Our ref: RA/2024/147049/02-L01
Your ref: 2024/90792

USE OF LAND FOR ASSEMBLY AND STORAGE AND FIT-OUT OF ACOUSTIC CONTAINERS OF CONTAINER-BASED GENERATOR UNITS WITH REINSTATEMENT OF ACCESS, ERECTION OF SECURITY FENCE AND SITING OF CABINS – FORMER WHITELEY ENGINEERING WORKS SITE, ST. PEG LANE, CLECKHEATON, BD19 3SH

We have reviewed the updated FRA prepared by Ashfield Solutions Group referenced 182623-F02 (Final – Rev A) dated 19 July 2024, submitted in support of this application and maintain our previous objection. Please see our updated response below.

Environment Agency position

Report No. 182623-F02	Drawing No. 02	Revision -
Scale As Shown	Date 26/01/2024	Frame Size A3
Produced By LC	Drawn By LC	Approved By RW

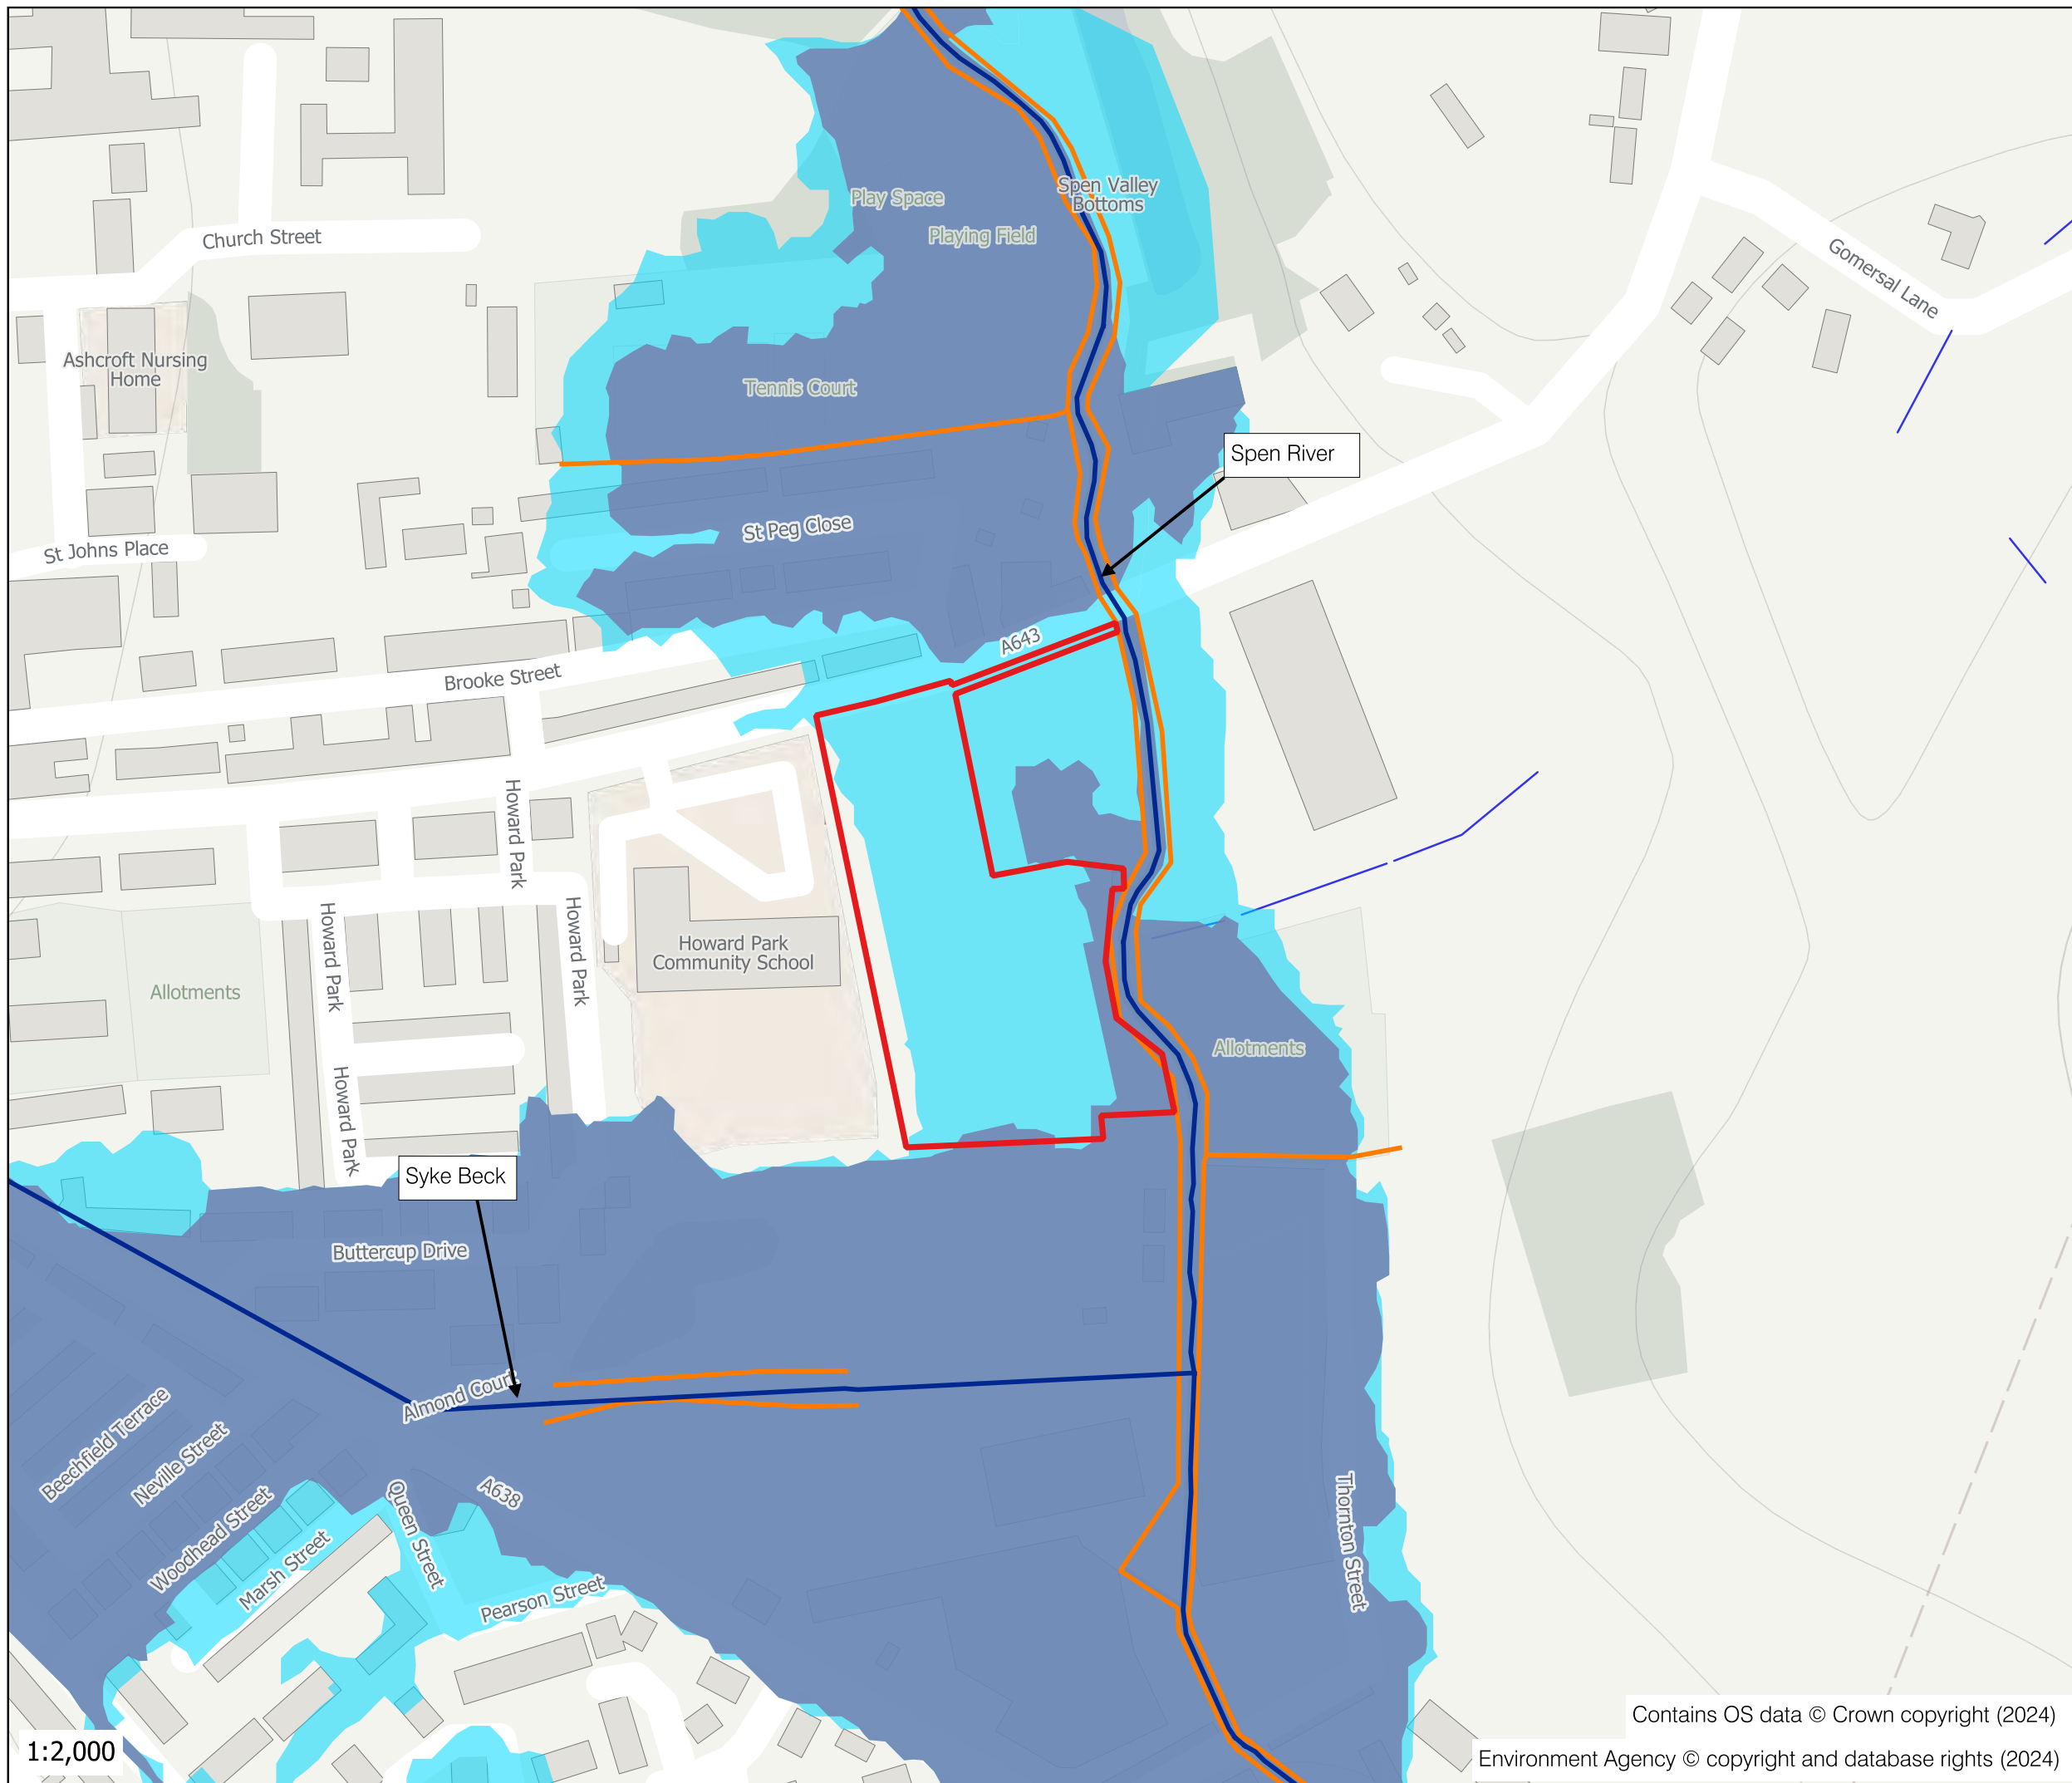
- Adequately assess flood risk to the site. We note that there are flood walls along the River Spen at the proposed development site. The FRA and any Flood Warning and Evacuation Plan should be updated with a consideration of residual risk arising from the flood walls.
- Demonstrate that the proposed development does not increase flood risk to others. We note that the FRA states “*The proposed development [...] Is unlikely to increase flood risk elsewhere as a result of the proposed development through the loss of floodplain storage, impedance of flood flows or increase in surface water runoff*” but does not provide any evidence to support this claim.

To overcome our objection, the applicant should submit a revised FRA which addresses the points highlighted above.
